19/12/2019

**SCEGGS Darlinghurst Concept and Stage 1 (SSD-8993)
Request for Additional Information**

I refer to Response to Submissions (RtS) lodged in relation to the development application for SCEGGS Darlinghurst Concept and Stage 1 (SSD-8993).

Project
SCEGGS DARLINGHURST
MASTERPLAN
Drawing Title
PROPOSED MASTERPLAN
ENVELOPE ELEVATIONS
Drawing No.
AR.MP.3002
Revision
D

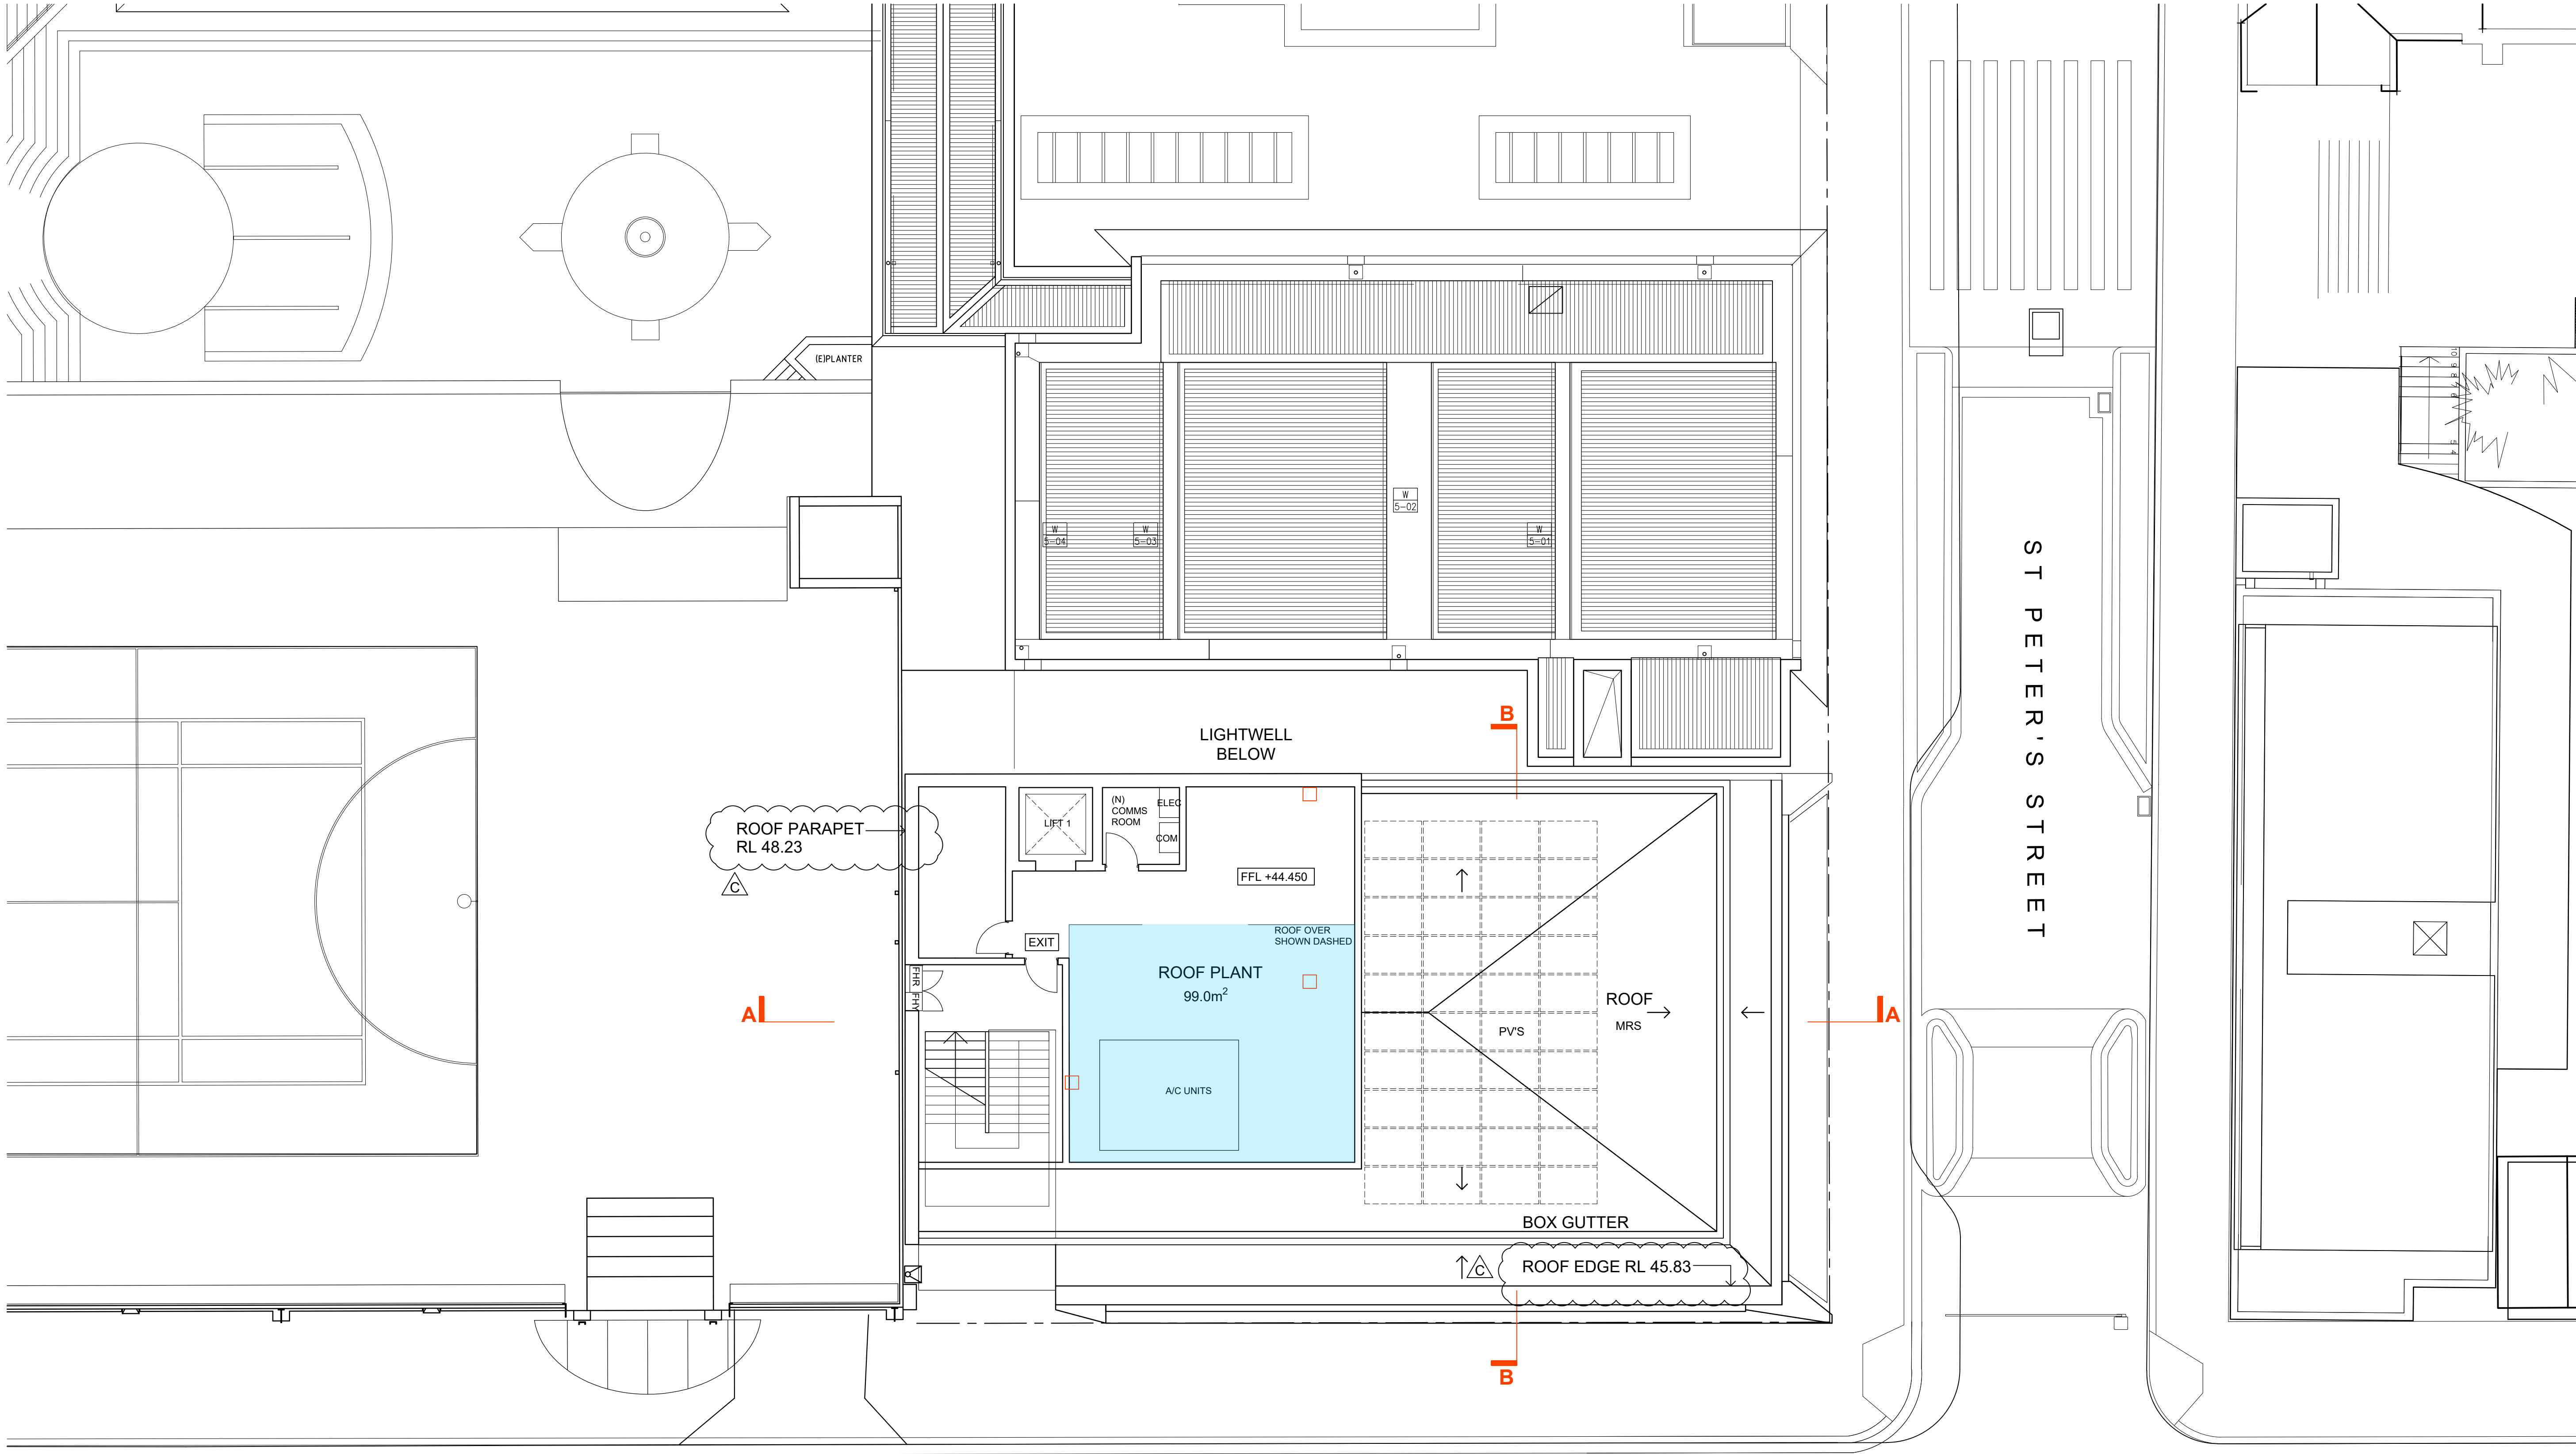
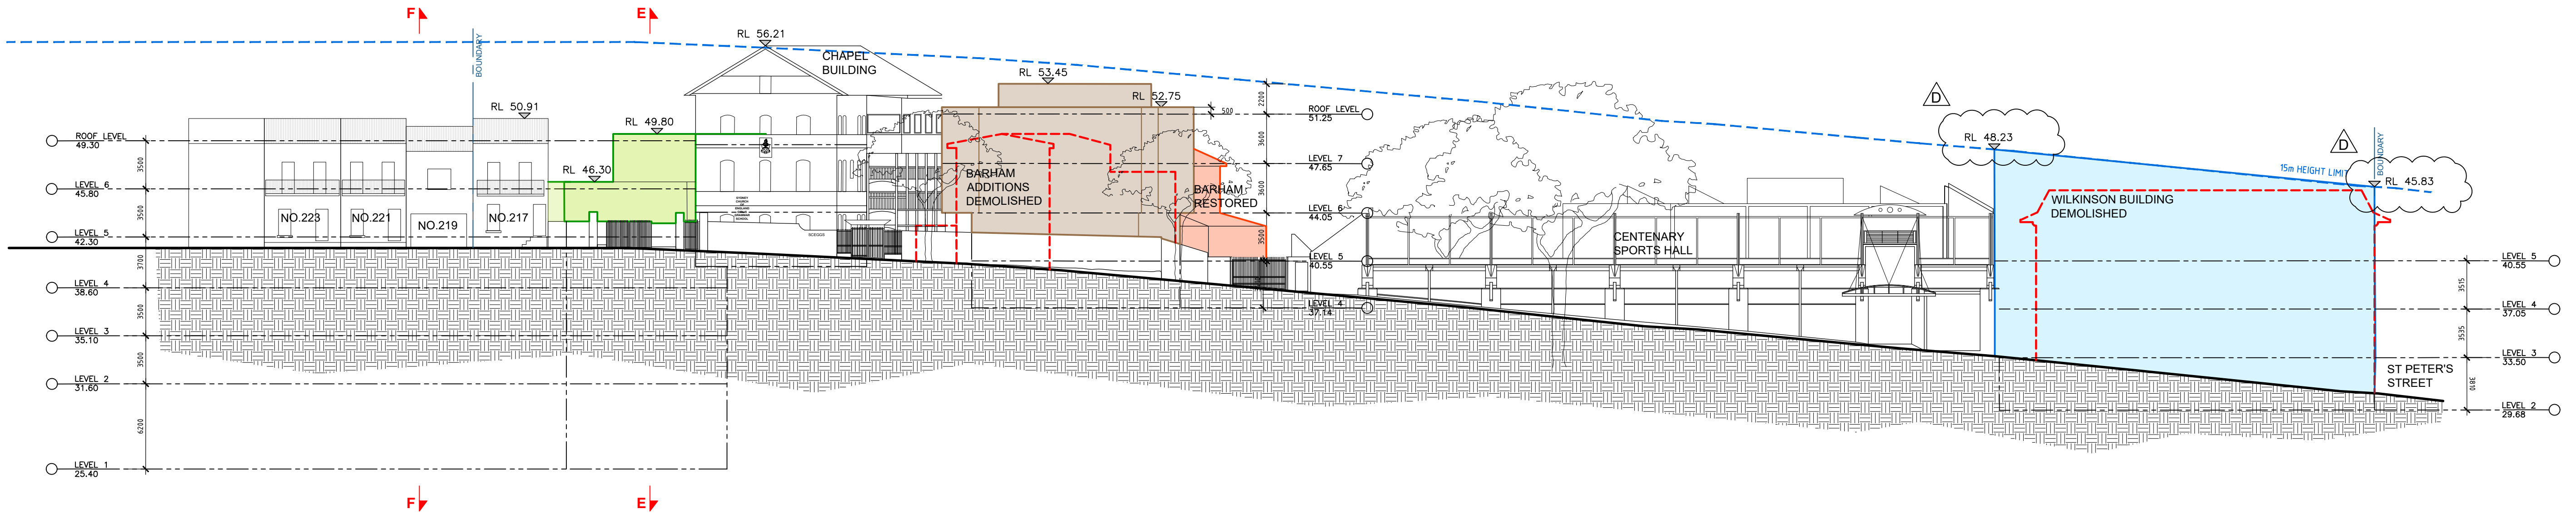
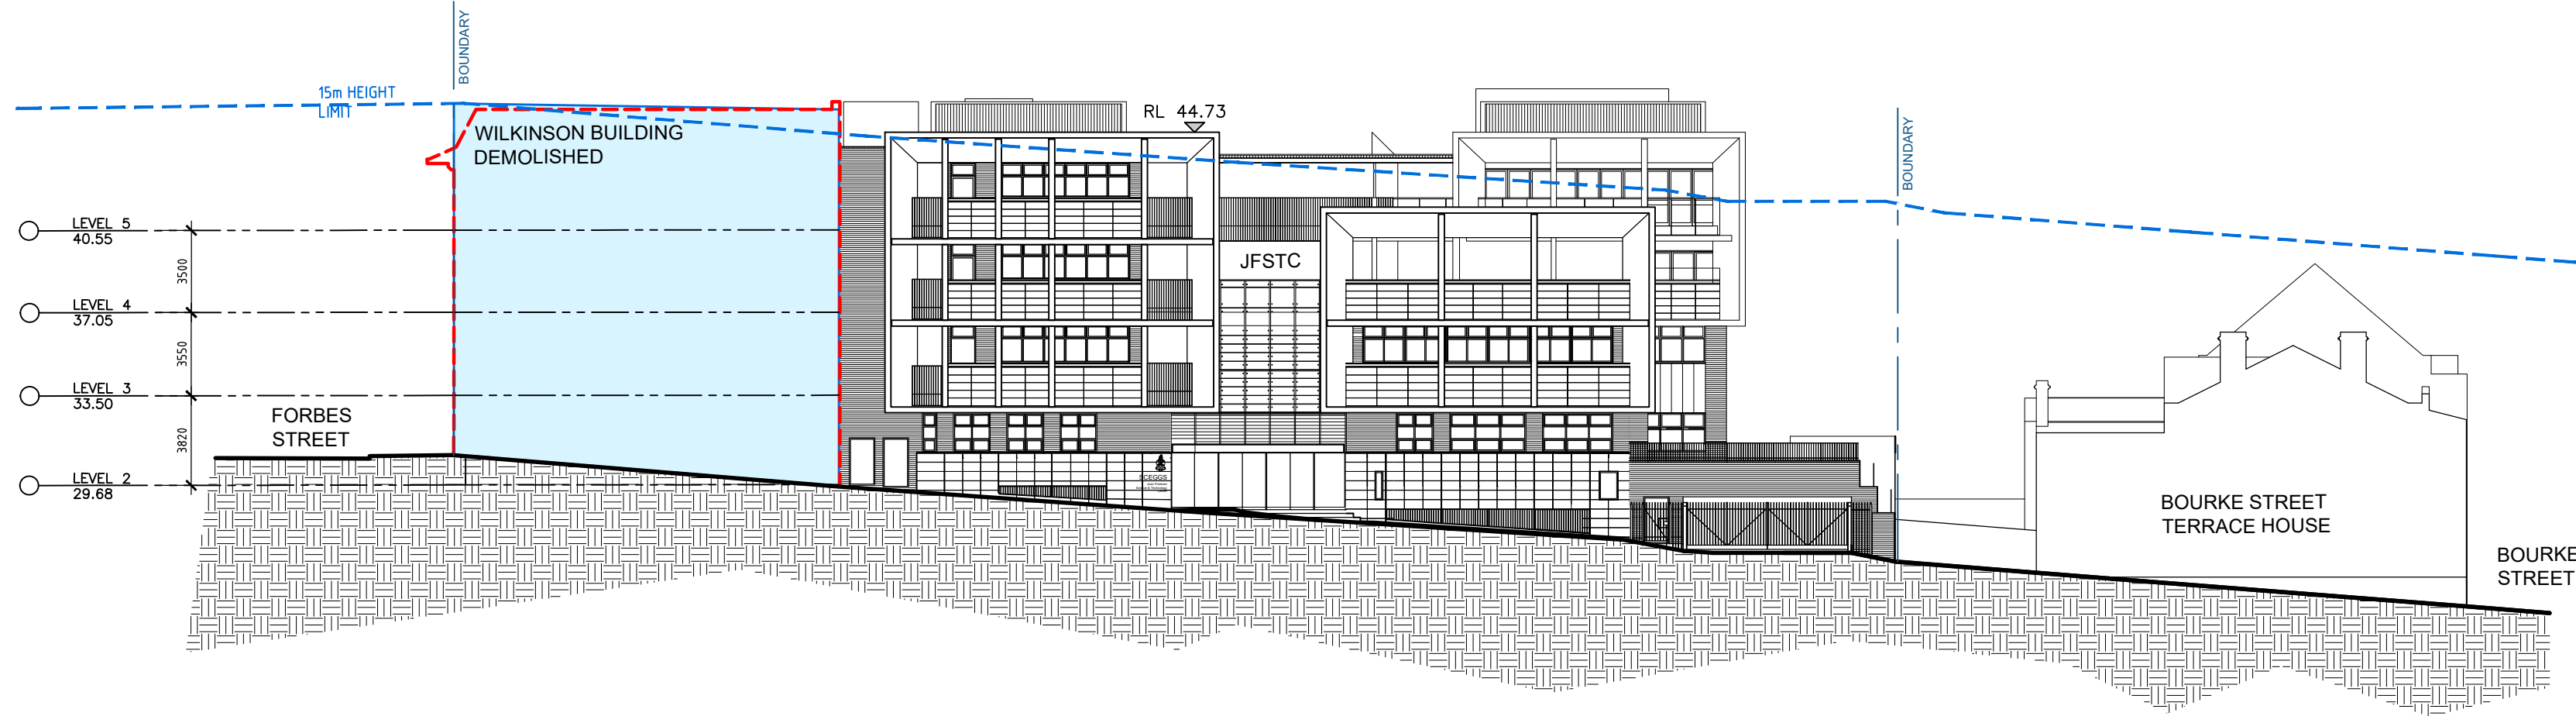
14. The Department notes that the architectural drawings (Concept and Stage 1) do not include the maximum RLs for Wilkinson House (drawings AR.MP.3002c, AR.DA.2105b, AR.DA.3002b). Provide updated architectural drawings annotated with the maximum RL heights (roof plan and elevation) for Wilkinson House, including highest point of plant enclosure(s).

Project
SCEGGS DARLINGHURST MASTERPLAN
Drawing Title
WILKINSON HOUSE REDEV. ELEVATIONS
Drawing No.
AR.DA.3002

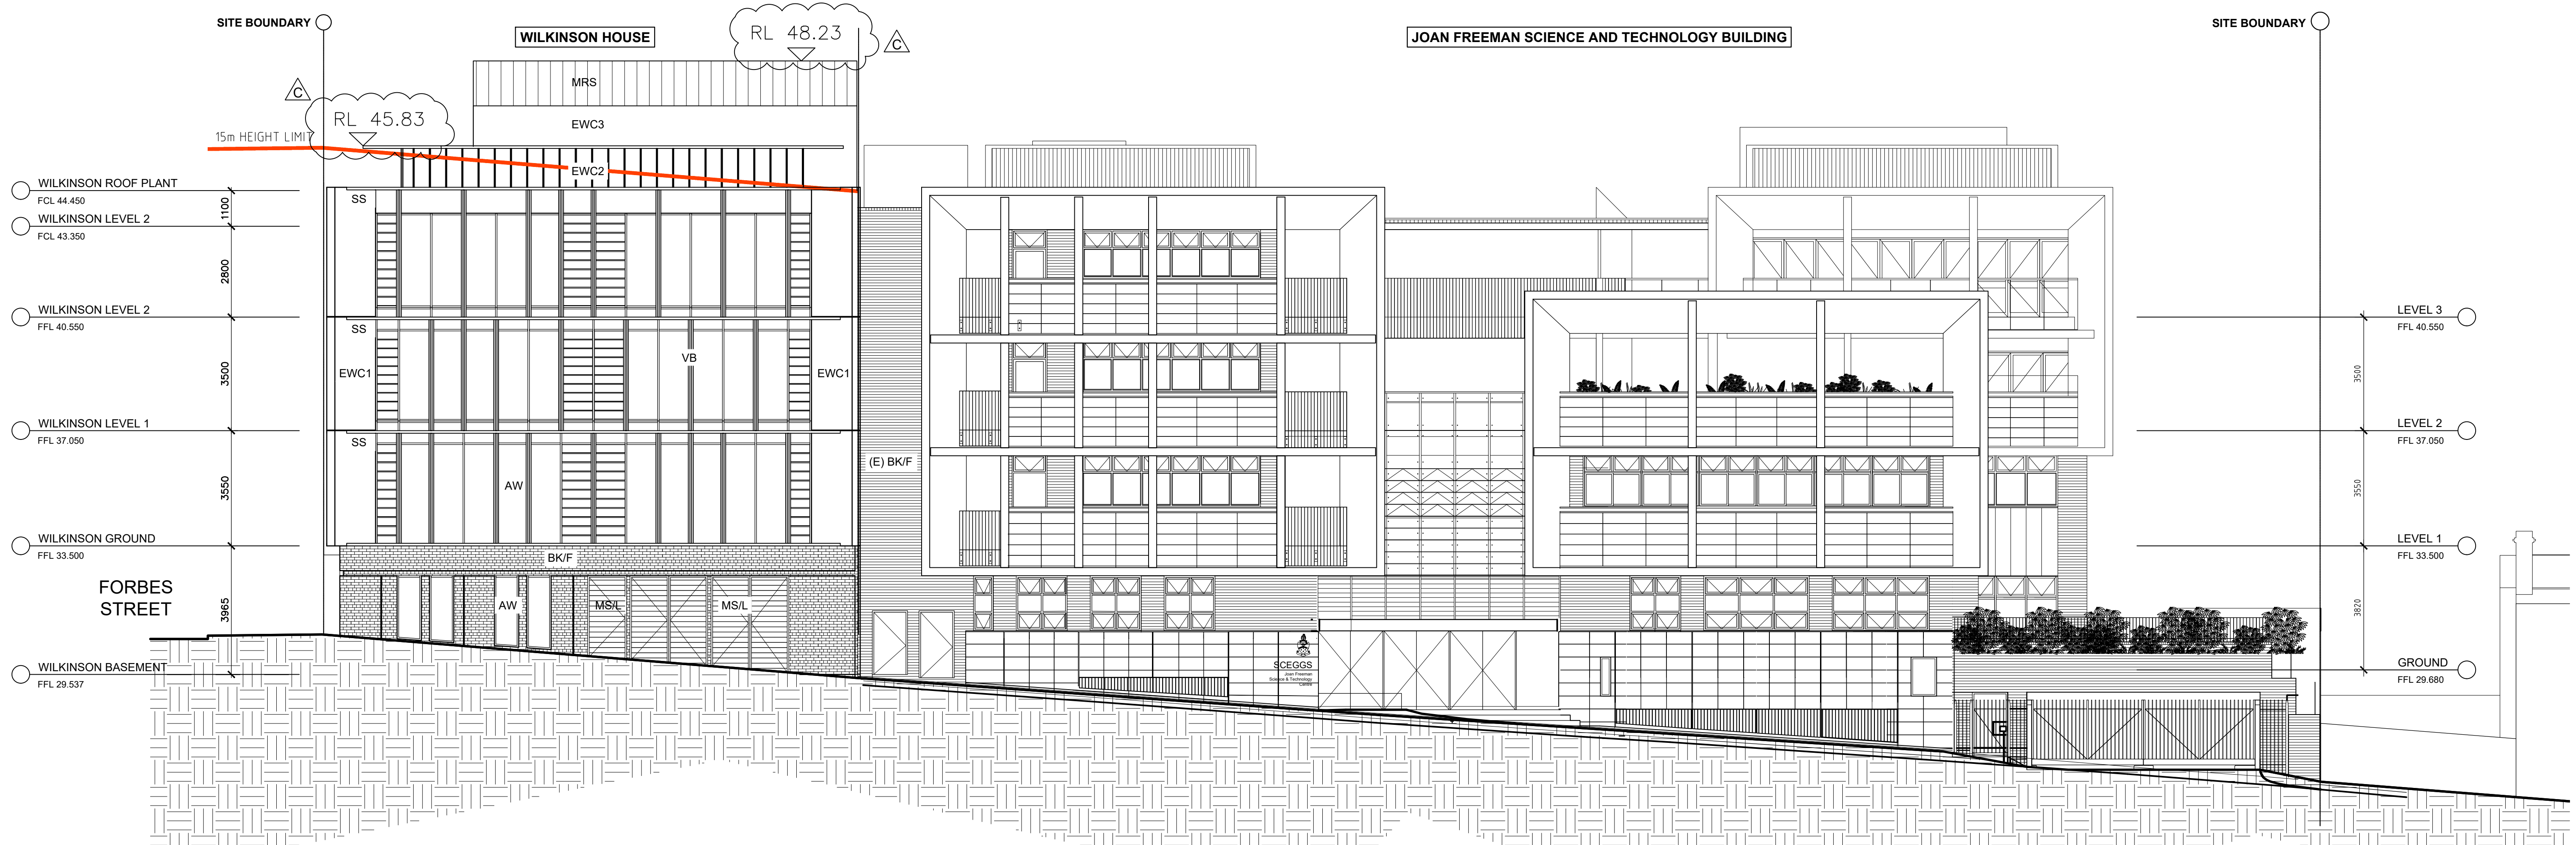
4. Confirm how the alcove created by the Wilkinson House recessed stair core on the Forbes Street frontage would be treated to prevent anti-social behaviour / litter and the like.
